Arun District Council
Arun Civic Centre
Maltravers Road
Littlehampton
West Sussex BN17 5LF
Planning & Building Control General Enquiries
Tel: (01903) 737756 Fax: (01903) 716019
Dx: 57406 Littlehampton
Minicom: 01903 732765
e-mail: planning@arun.gov.uk
website: www.arun.gov.uk/planning

Your Ref: FN/72/10/DOC

Article 21 of the Town and Country Planning (General Development Procedure) Order 1995
Application for discharge of condition no 14 & 15 in relation to FN/33/10/
Plot B1 Coventry Plantation Horsham Road, Findon,

Site Plan 1:500 @ A3
Findon Travler Site
Plot B1
Coventry Plantation
Horsham Road
Findon
West Sussex
BN14 0RG

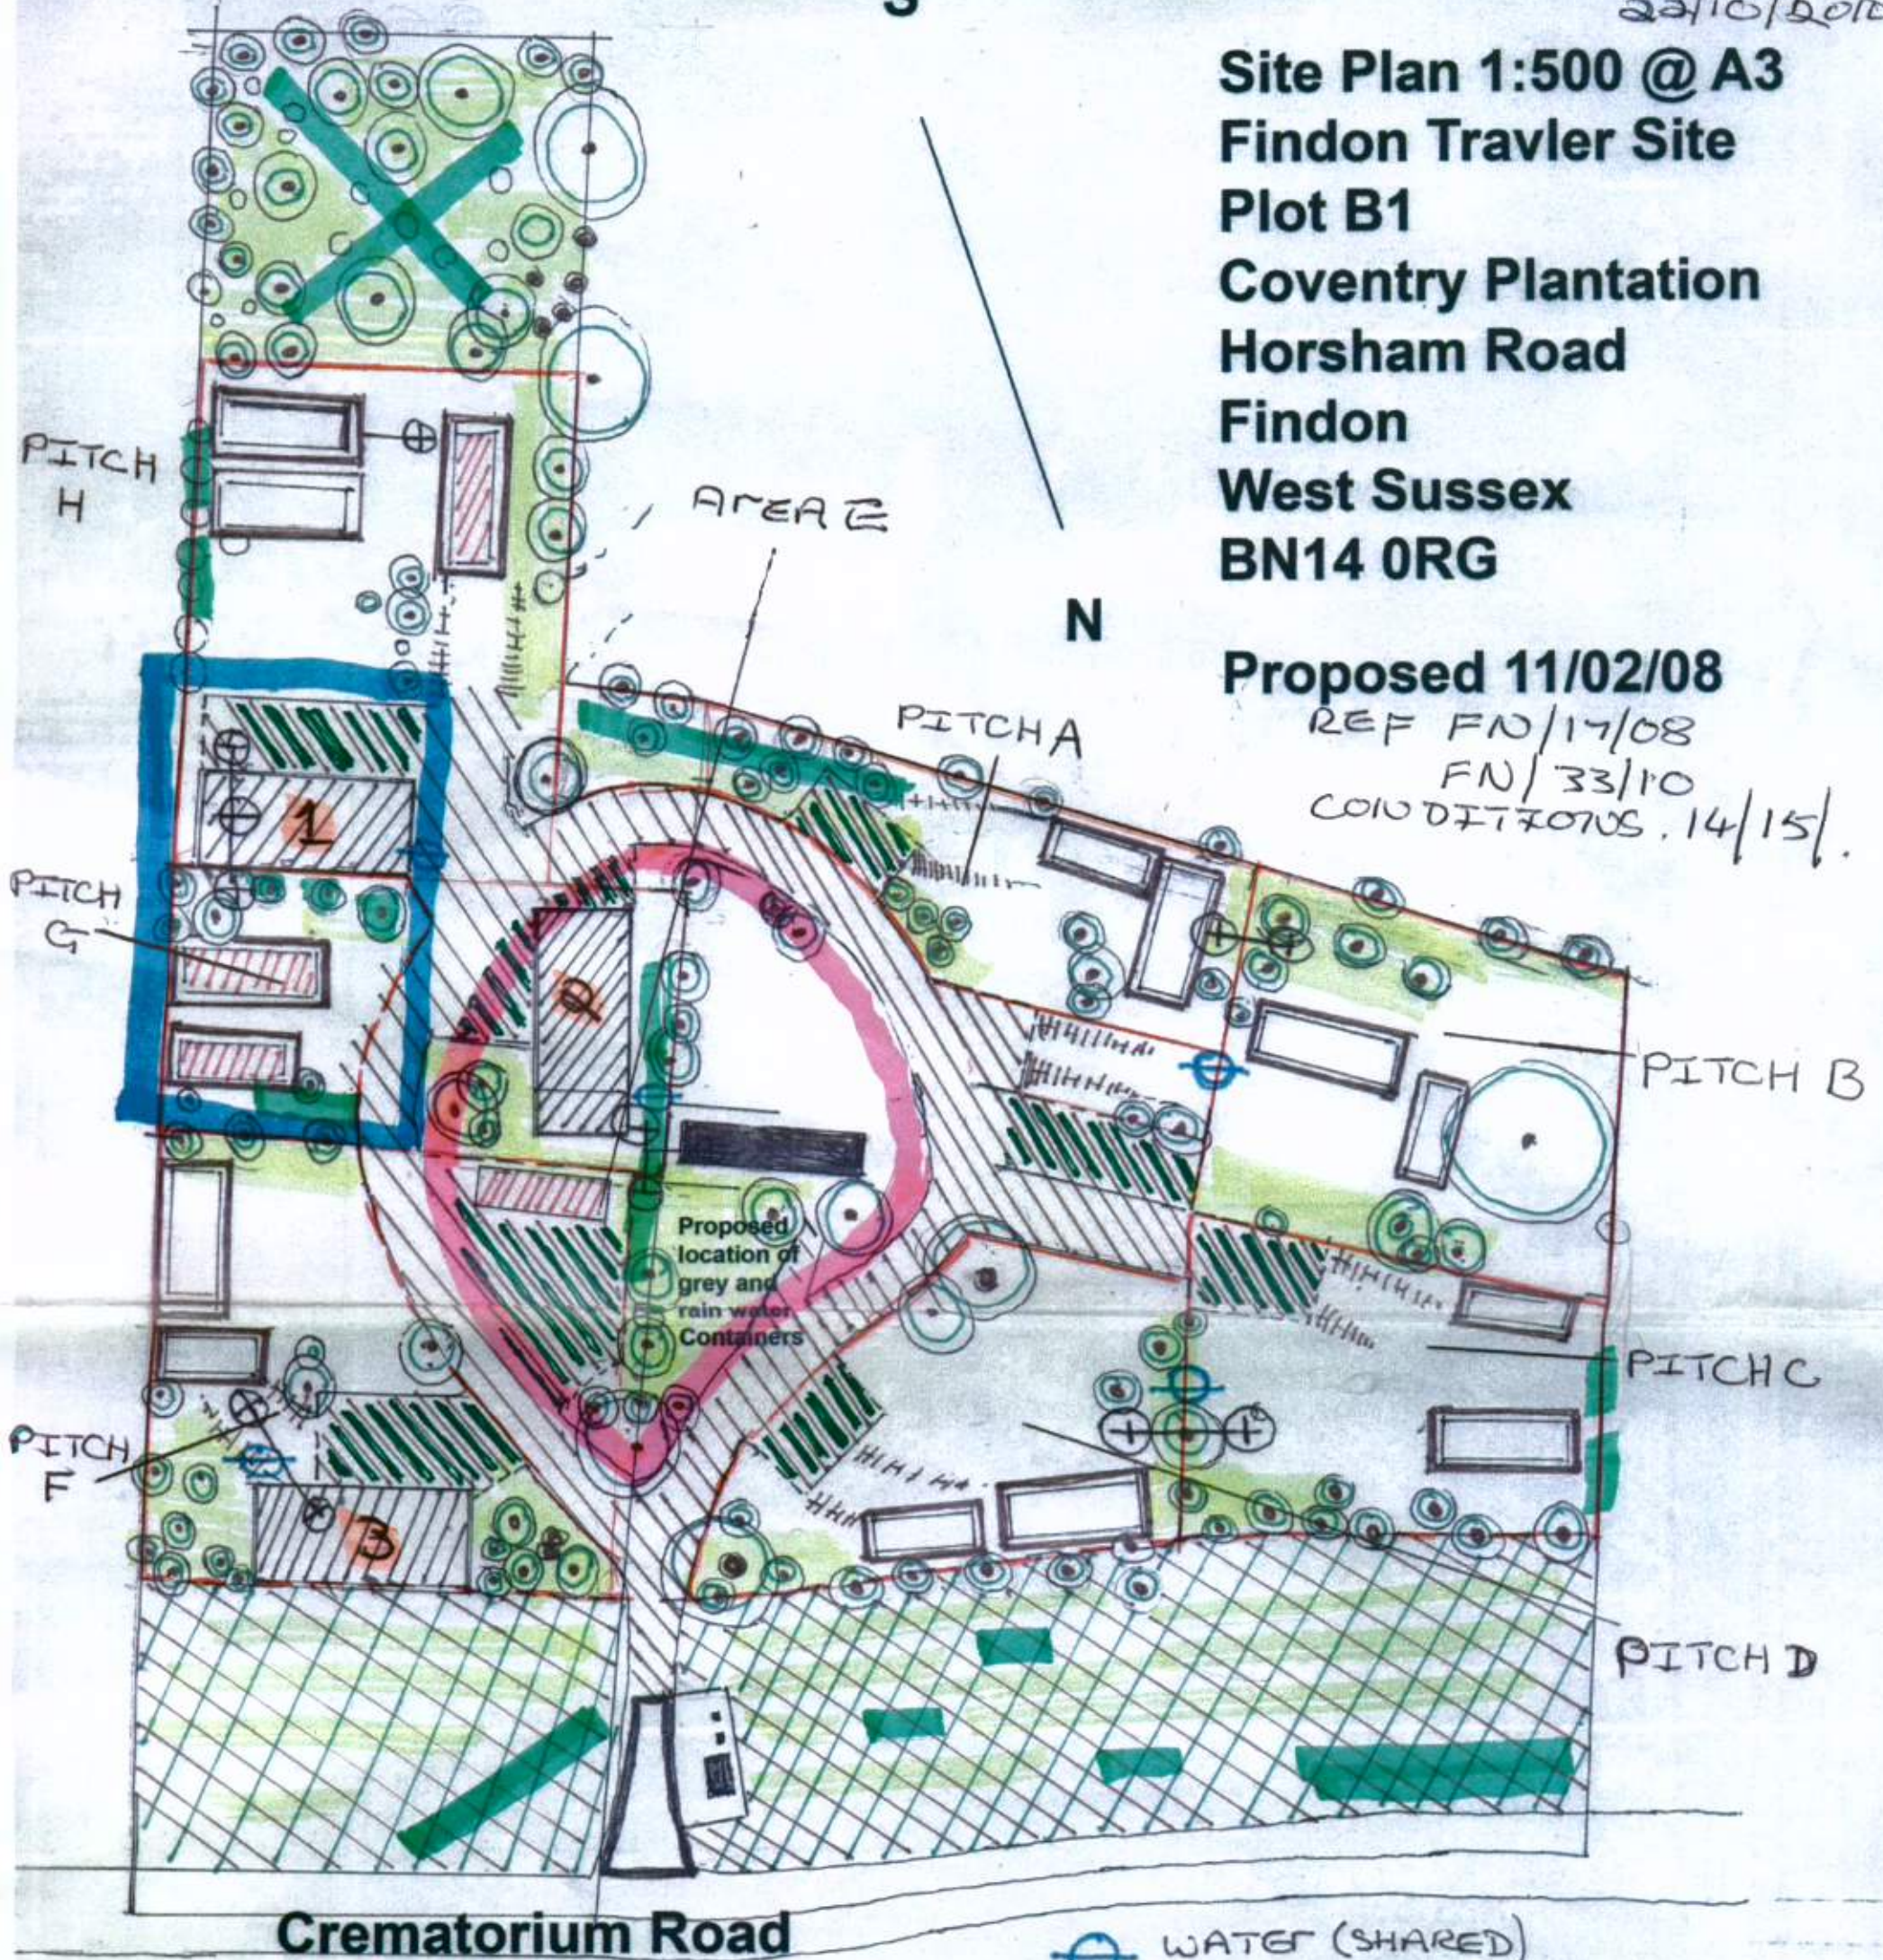
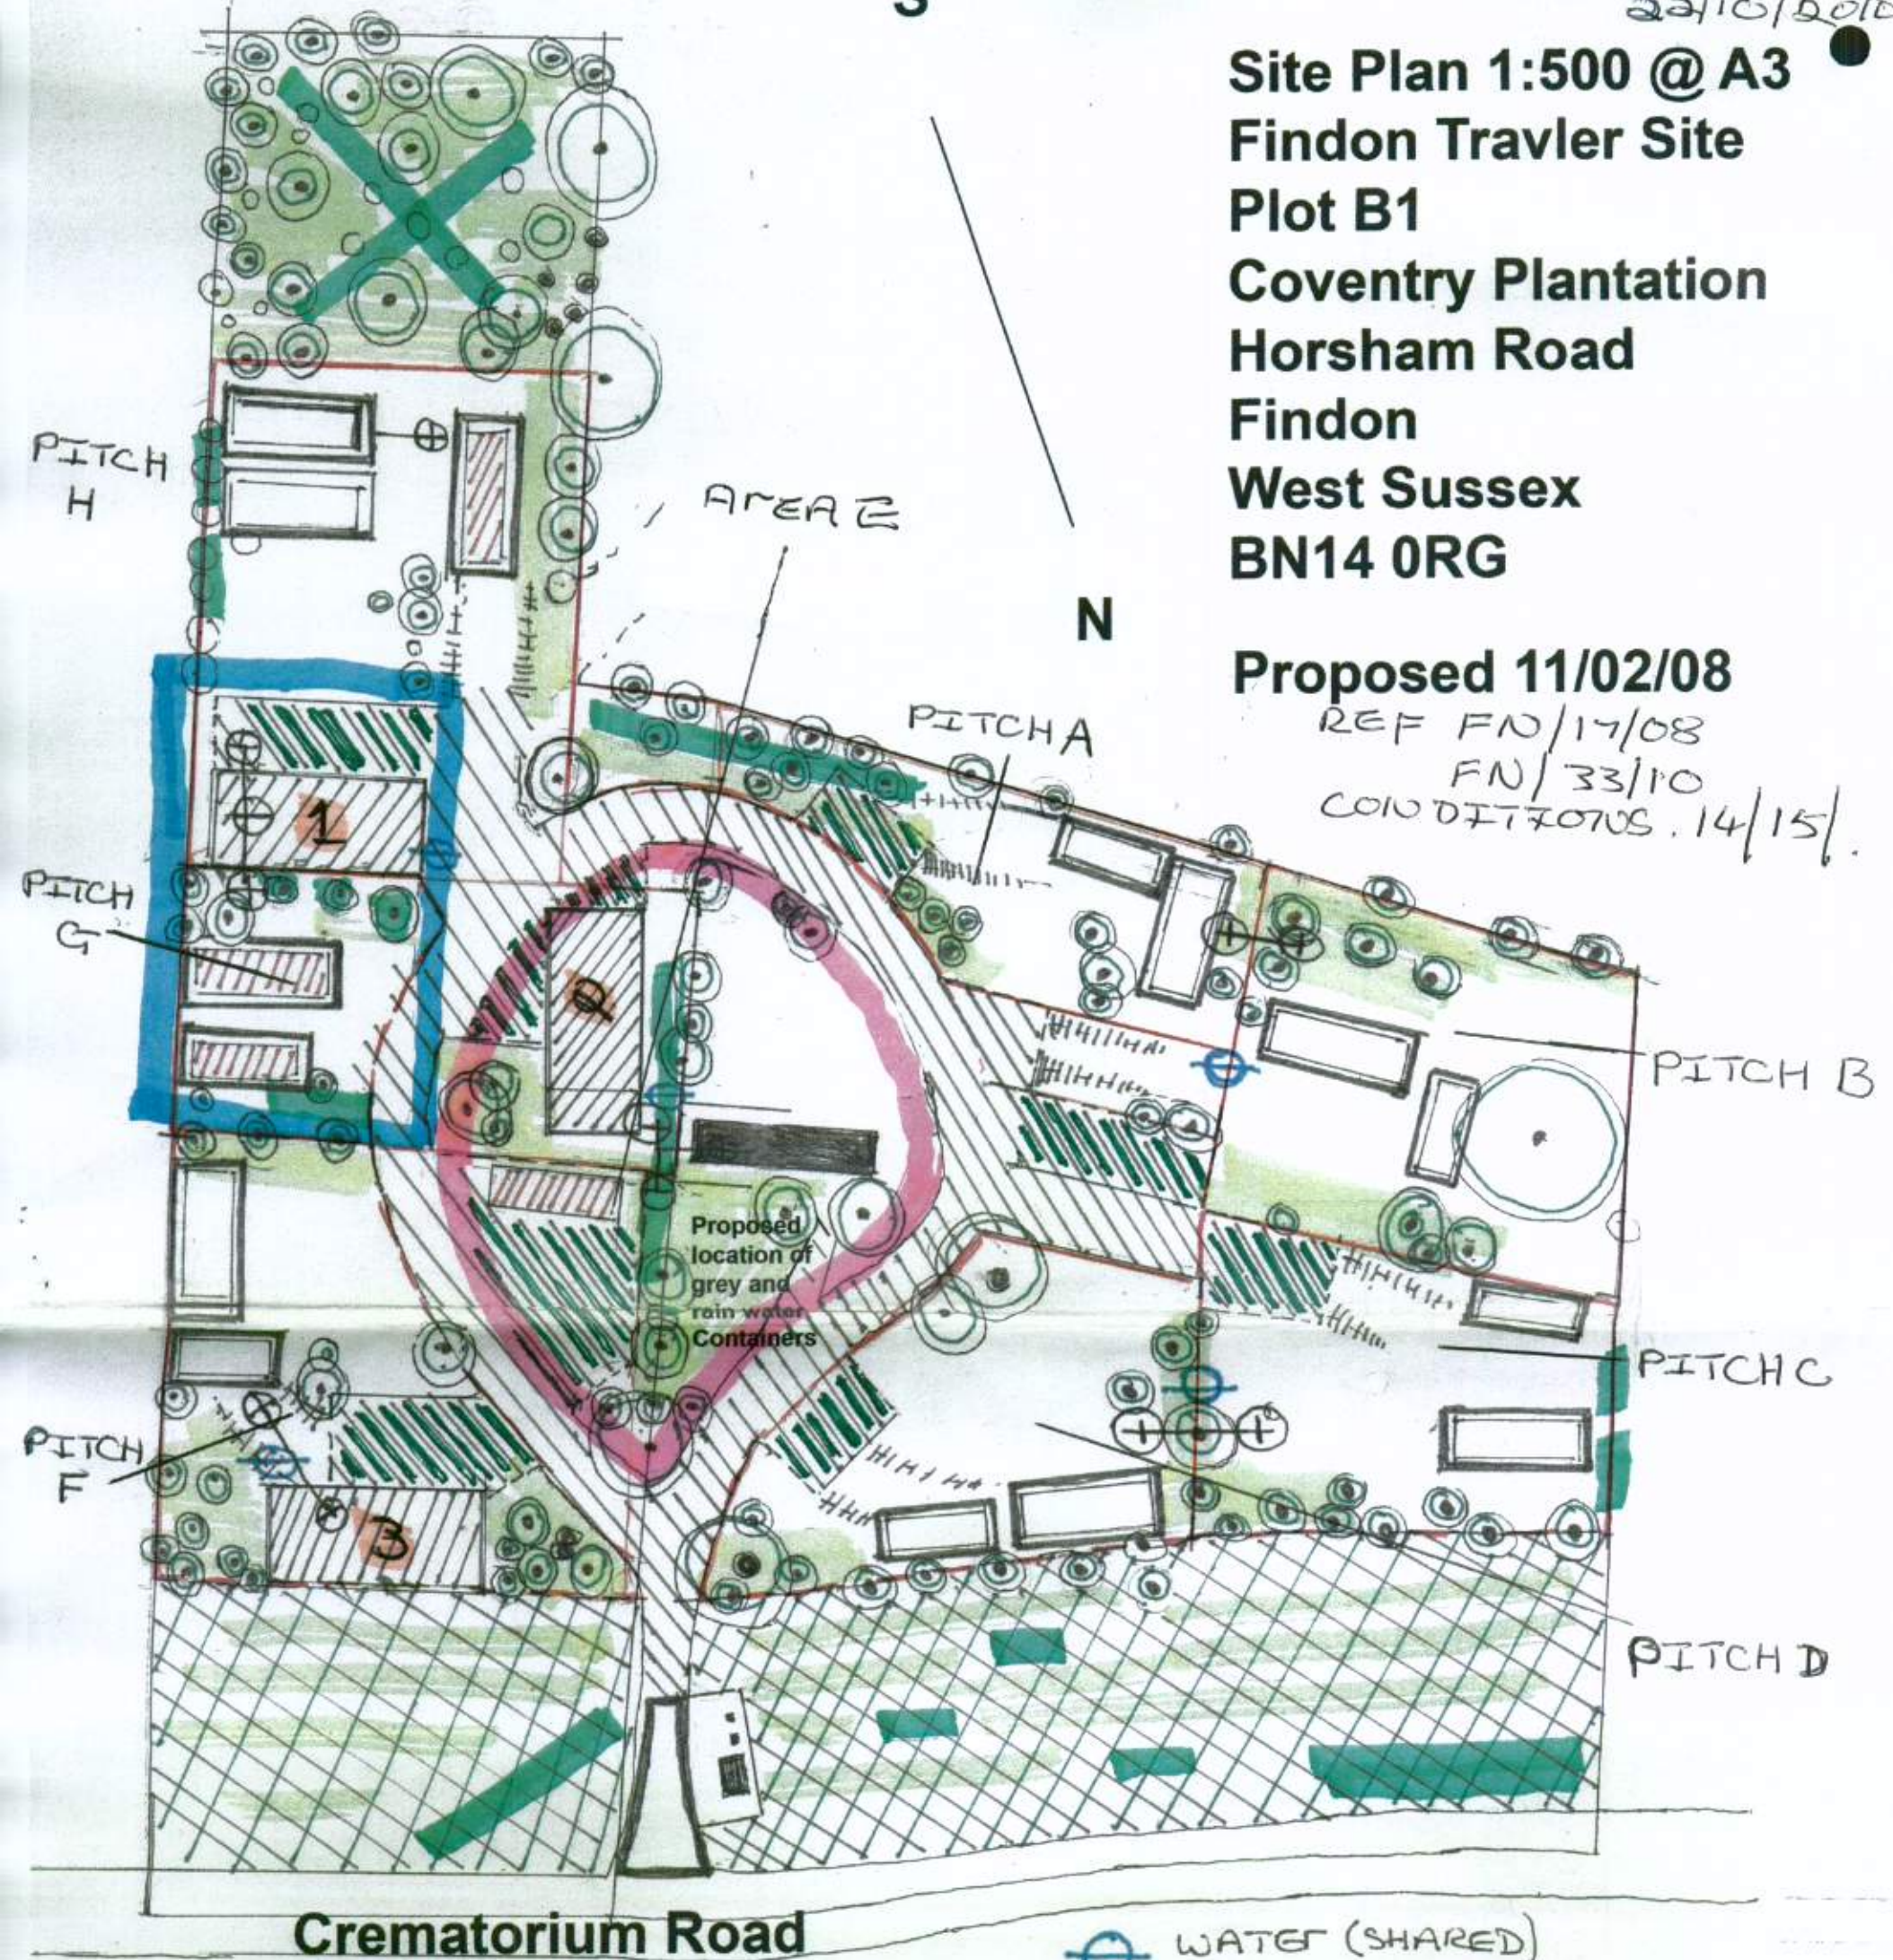
The information submitted is insufficient to discharge the condition. Whilst the new planting plan may refer to the existing planting the condition requires further planting. No significant new planting is identifiable within the submitted scheme and this should be clearly identified.
